NORTH FALLS OFFSHORE WIND FARM

Appendix H4.1 to Natural England's Deadline 4 Submission

**Natural England's LBBG Proposed Compensation Site Advice on the Applicant's
Deadline 1 Documents [REP1-018, REP1-020, and REP1-044]**

25 April 2025

Figure 3 LBBG Compensation short-listed sites at the AOE SPA LBBG search area

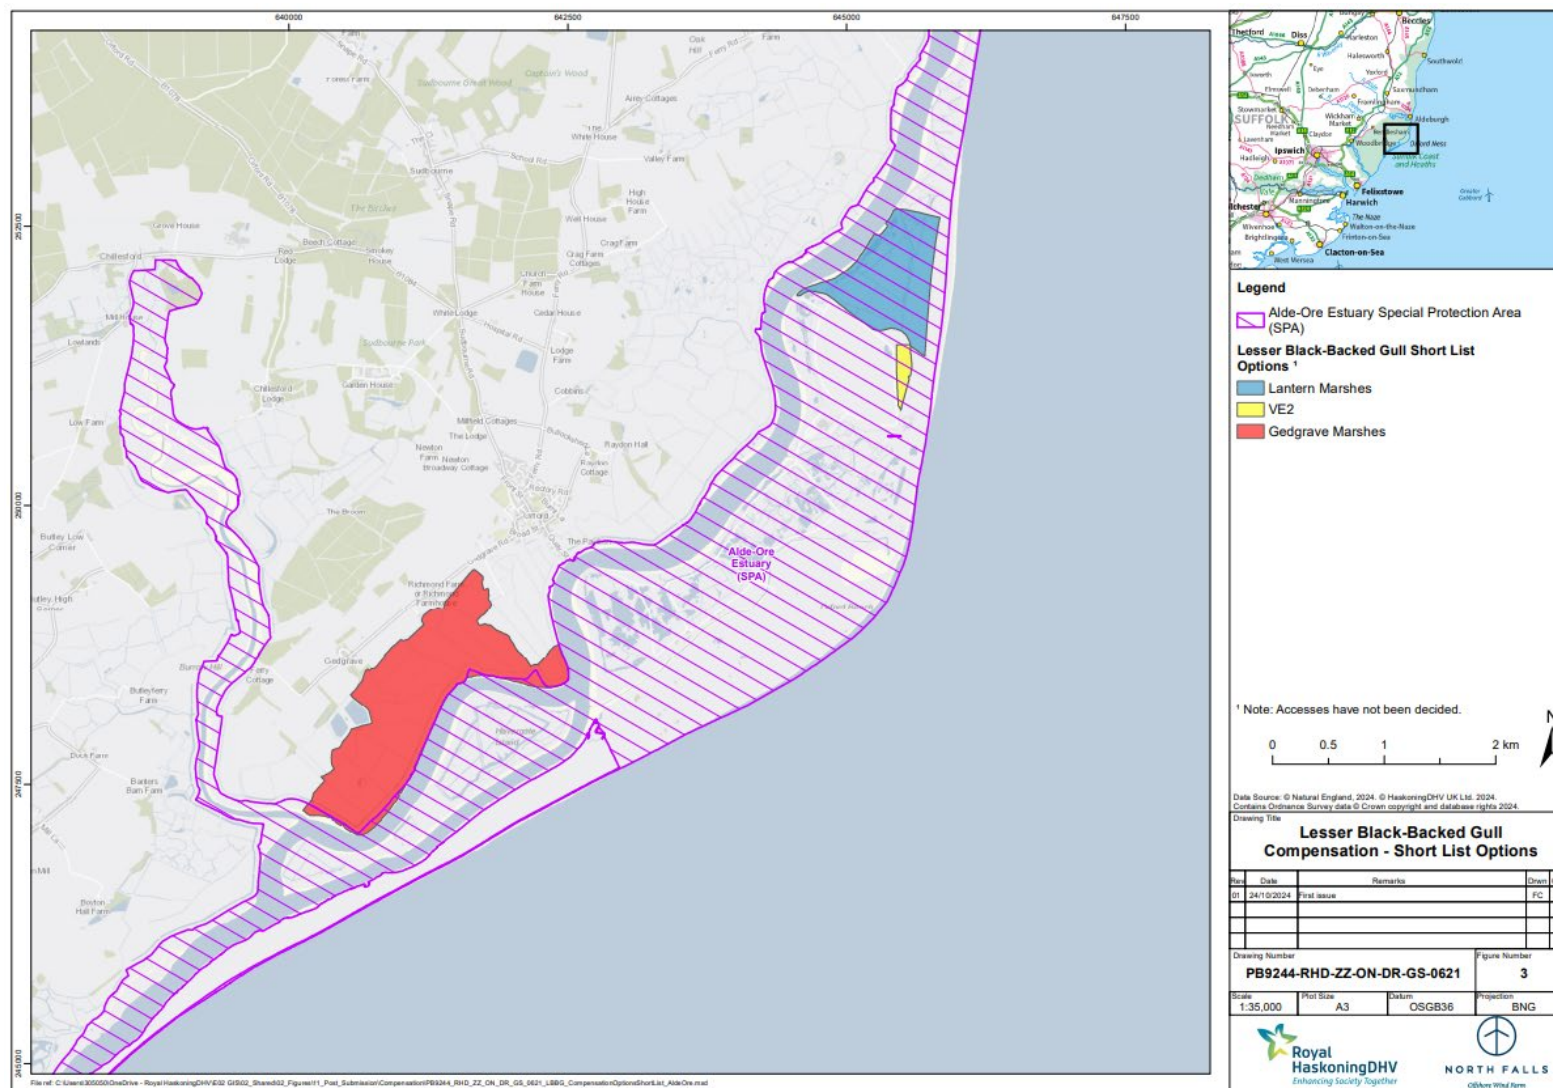
Document reviewed	Update made	Issue resolved? Yes/No/Progressed
[REP1-018] 7.2.2 HRA LBBG Comp (Rev 1)	<p>We note that Shingle Street has been removed as a proposed LBBG compensation site option, whilst Gedgrave Marshes has been added. The Gedgrave Marshes site is adjacent to, but not within, designated sites and is on agricultural land that does not have evidence of previous usage by LBBG for nesting. The area of Gedgrave Marshes that would be fenced (as a compensation site) is currently grassland opposite Havergate Island, where a large LBBG colony exists.</p> <p>The proximity of Gedgrave Marshes to the Alde-Ore Estuary Special Protection Area (AOE SPA), Ramsar and Special Site of Scientific Interest (SSSI) and the presence of suitable habitats for wintering waterbirds indicates there is potential for functional linkage to designated sites. This is reinforced by Gedgrave Marshes being a High Priority Wetland Bird Survey (WeBS) count sector (Alde Estuary Sector 8 Location 33448), highlighting the site's likely usage by SPA waterbirds. Accordingly, we advise that the Applicant will need to carry out an assessment of the potential implications of the proposed measures on waterbird features of the SPA/Ramsar site through the HRA process, and if warranted identify appropriate mitigation measures for the construction and operational phases to minimise effect</p>	New issue.
